Replacement of 2 No. timber windows, 1 No. timber bay window & 1 No. timber door all with PVCu windows (only bedroom window will be sliding sash) & door. This application affects the character & appearance of The Steyne, Bognor Regis Conservation Area.

8A Sadler Street Bognor Regis

Title
Floor Plans

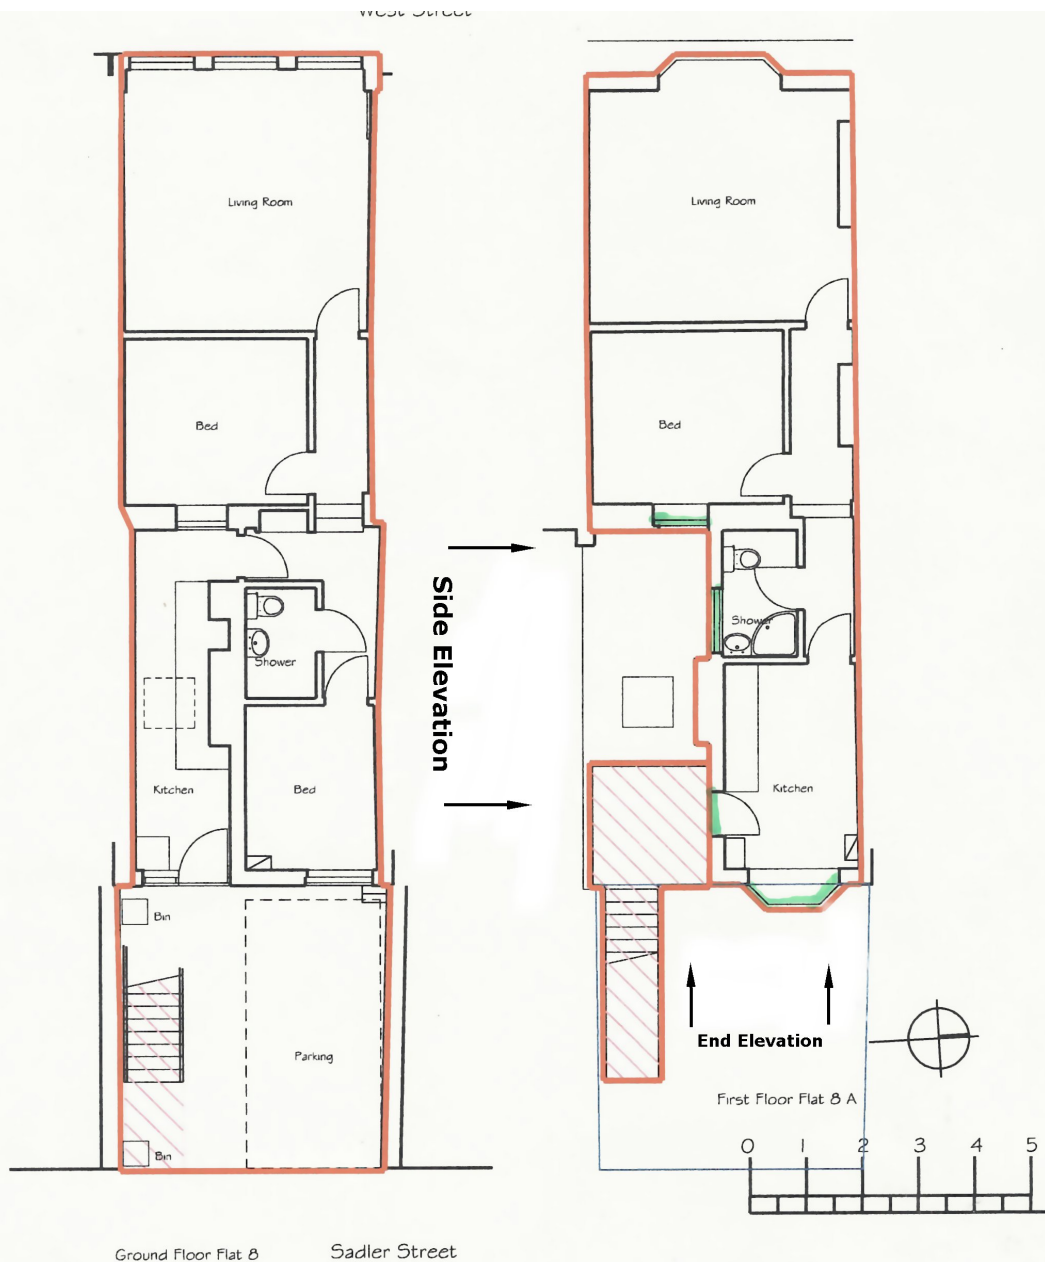
The proposed fenestration will be detrimental to the appearance of the conservation area. It will harm the character of the conservation area in conflict of NPPF 2019 Paragraph 192 (heritage assets - includes Conservation Areas), Paragraph 127 (design quality); Arun District Local Plan 2018, Policy HER DM3 (Conservation Areas), Policies DSP1 and DDM1 (design quality)
